Appeal Decision

Appeal Ref: APP/R5510/D/23/3319021

63 Long Drive, Ruislip HA4 0HN

- The appeal is made under section 78 of the Town and Country Planning Act 1990 against a refusal to grant planning permission.
- The appeal is made by Mr Surinder Sidhu against the decision of the Council of the London Borough of Hillingdon.
- The application Ref 47034/APP/2022/3861, dated 21 December 2022, was refused by notice dated 9 February 2023.
- The development proposed is 2 storey side extension and part rear extensions.

| <b>drawing number</b>                                                                                                                               | SIDHU/PLAN/004                                   |

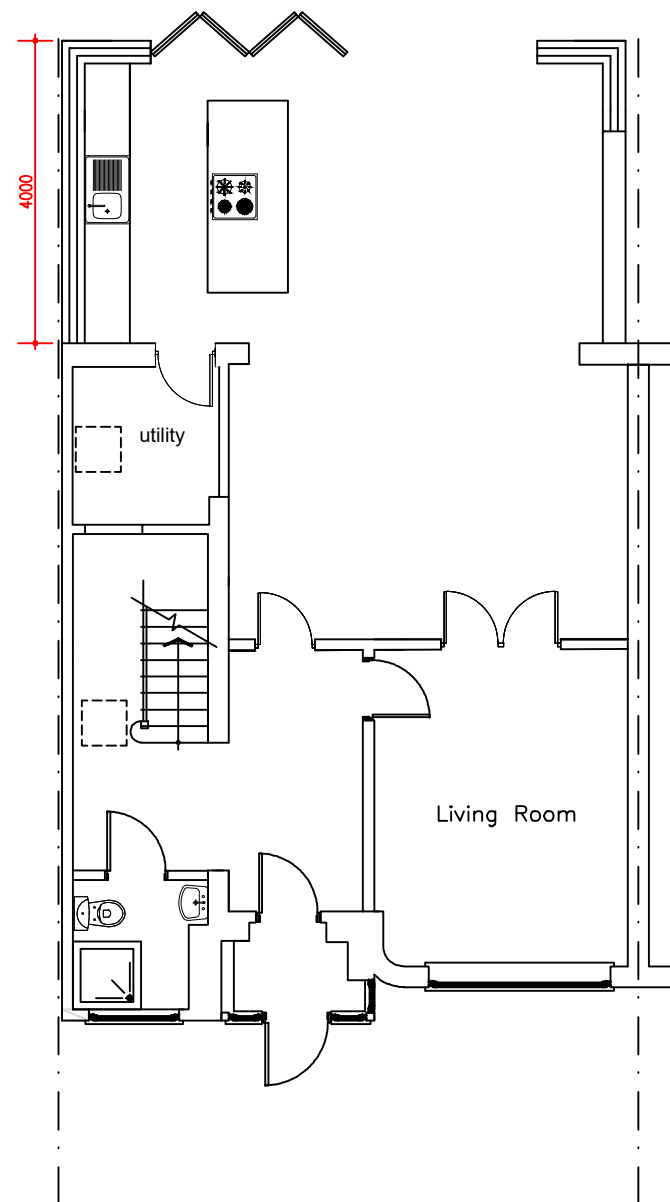
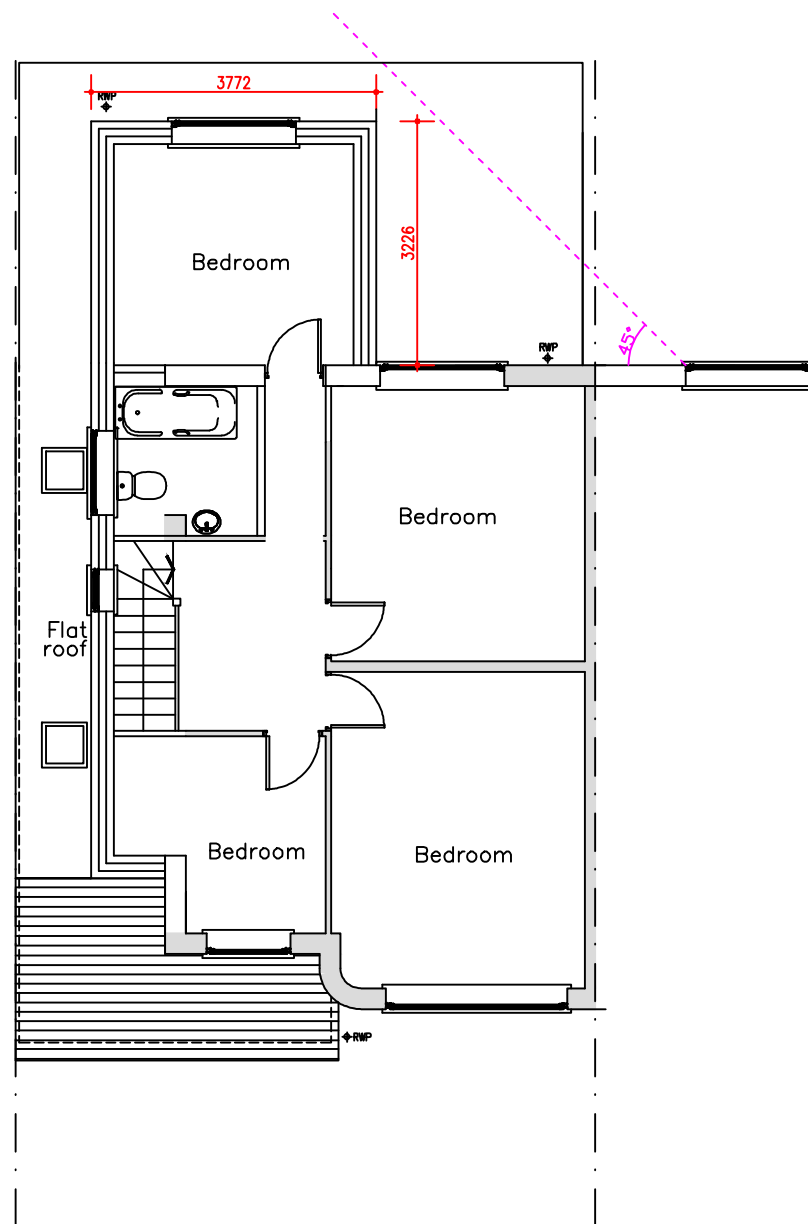
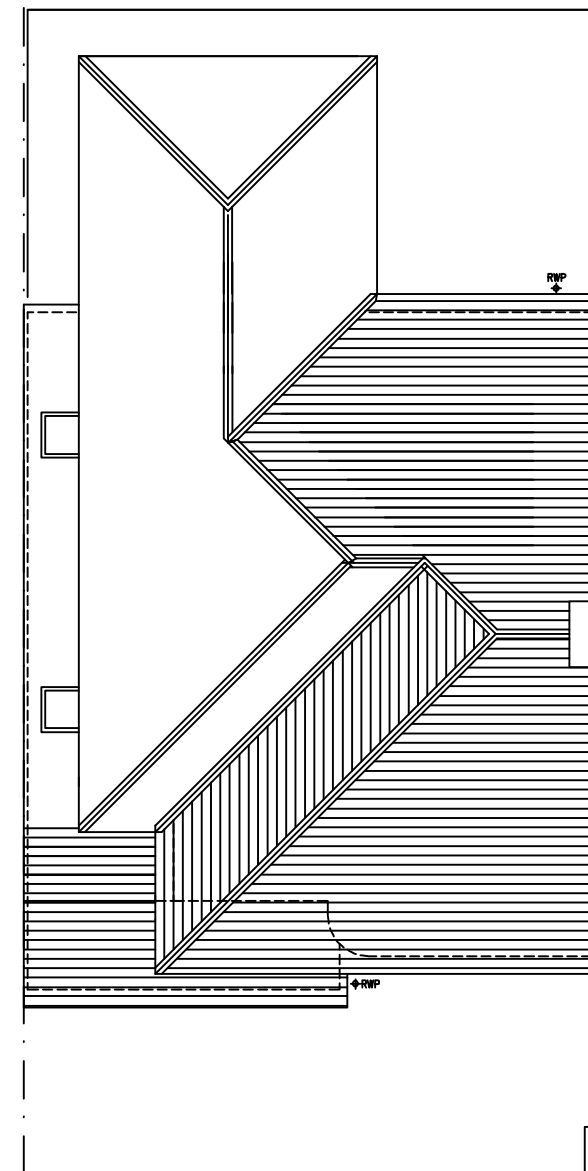
4. The side elevation of the existing rear extension to No 63 is set in from the shared boundary. It is proposed to infill this area and to construct an extension projecting some 2m beyond the existing rear wall. The boundary treatment would be retained. The site-specific circumstances of this case lead me to conclude that development closer to the boundary would have a minimal, but acceptable, additional impact on the neighbours' living conditions in terms of the potential for loss of light and outlook from the rear windows and patio. The proposed extension would not be a more overbearing form of development than that which already exists. The property at No 71 is not extended at the rear and therefore the proposed development would not enclose any space, or thereby lead to the creation of a sense of enclosure for No 69 as the Council states. For the foregoing reasons, the single storey element of the appeal proposal would not harm neighbouring living conditions.

5. No 69's first-floor window nearest to the proposed development appears to serve a bathroom. The rear bedroom window is some distance from the shared boundary. A 45-degree sight line has been provided to demonstrate that the first-floor extension would have no adverse effect on daylight and sunlight levels to habitable rooms. The Council raises no specific objections to the first-floor element of the proposal and there are no reasons to disagree. The proposal would be acceptable in this regard.
